MEMORANDUM

SUBJECT: On-Call Contract #17-067H-1; PO # 8113073
Bridge Reviews
Task Order #6: Mesa Top Bridge Submittal - Second Review

Mesa Top Bridge Submittal – Second Review

FOREST LAKES FILING NO. 6
 BRIDGE HYDRAULIC INFORMATION
 MESA TOP DRIVE OVER NORTH BEAVER CREEK

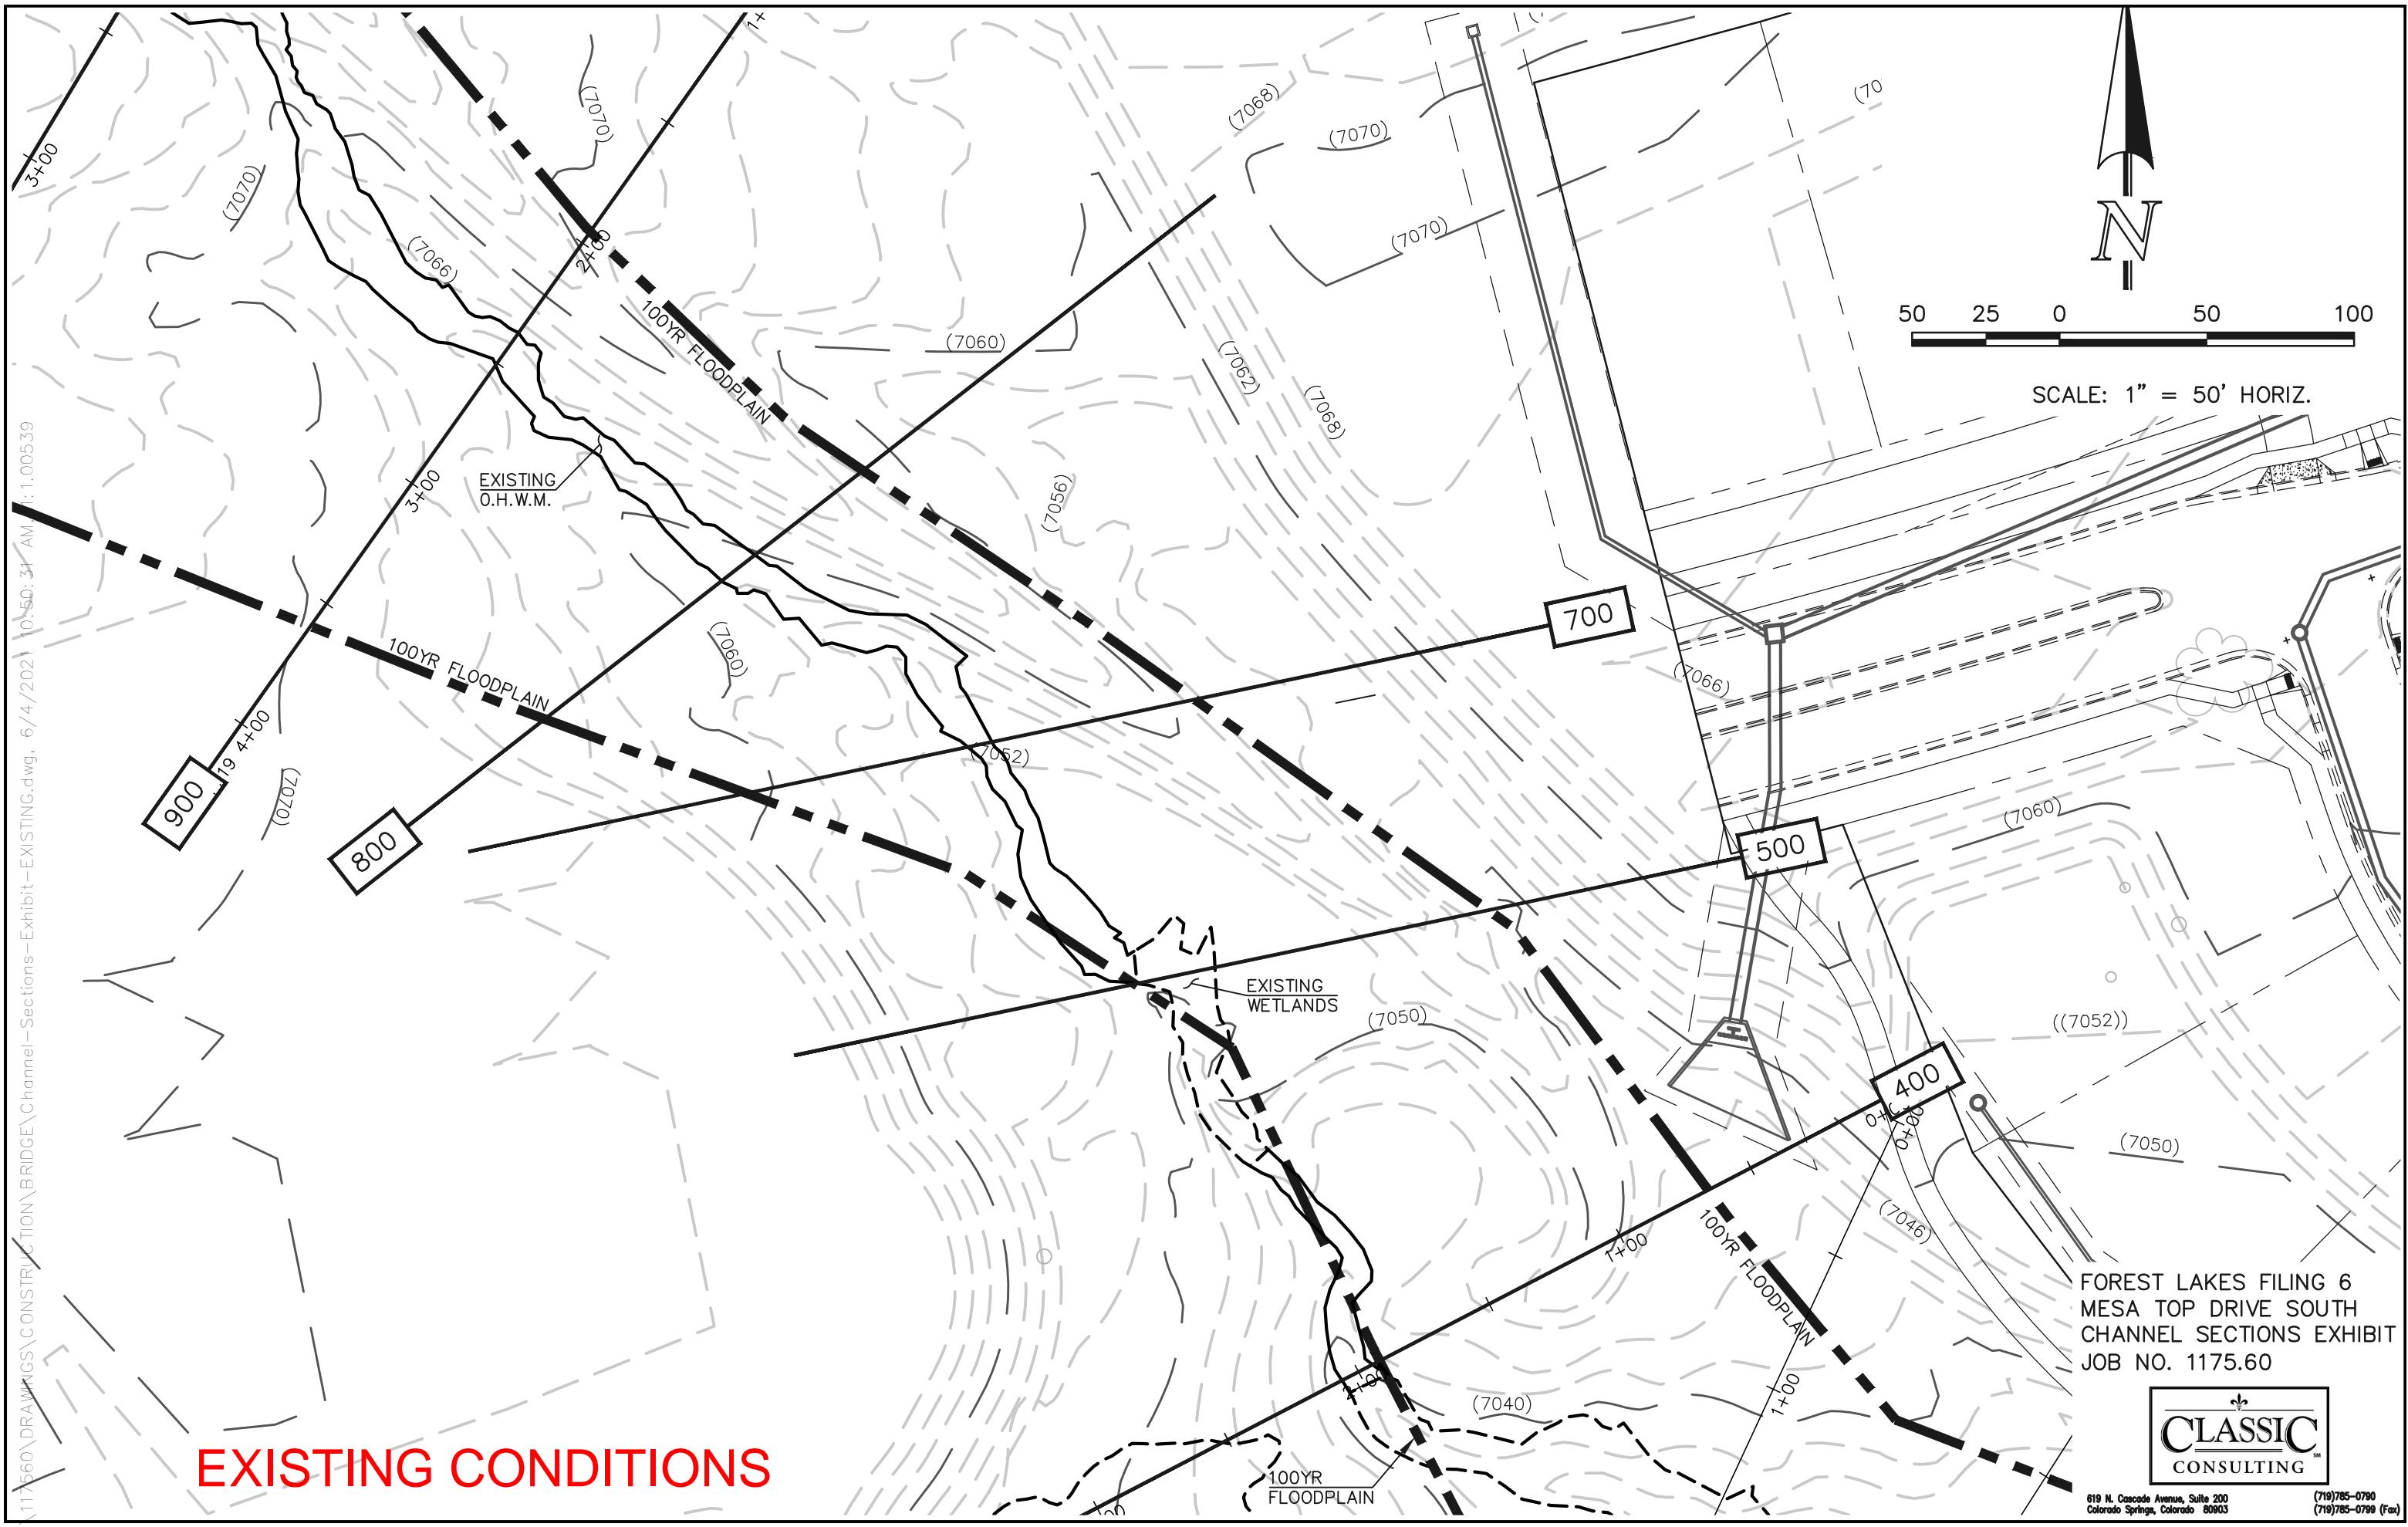
Bridge Hydraulic Information Plan Sheet:

1. How are the limits of riprap being defined? What are the dimensions? What is the riprap size? Is there bedding or geotextile proposed? What is the riprap thickness?
2. Show scour limits.
2. In the view for Mesa Top Drive Bridge (South Bridge HCL) (Looking Downstream), should the riprap be extended to the bottom of the slope?
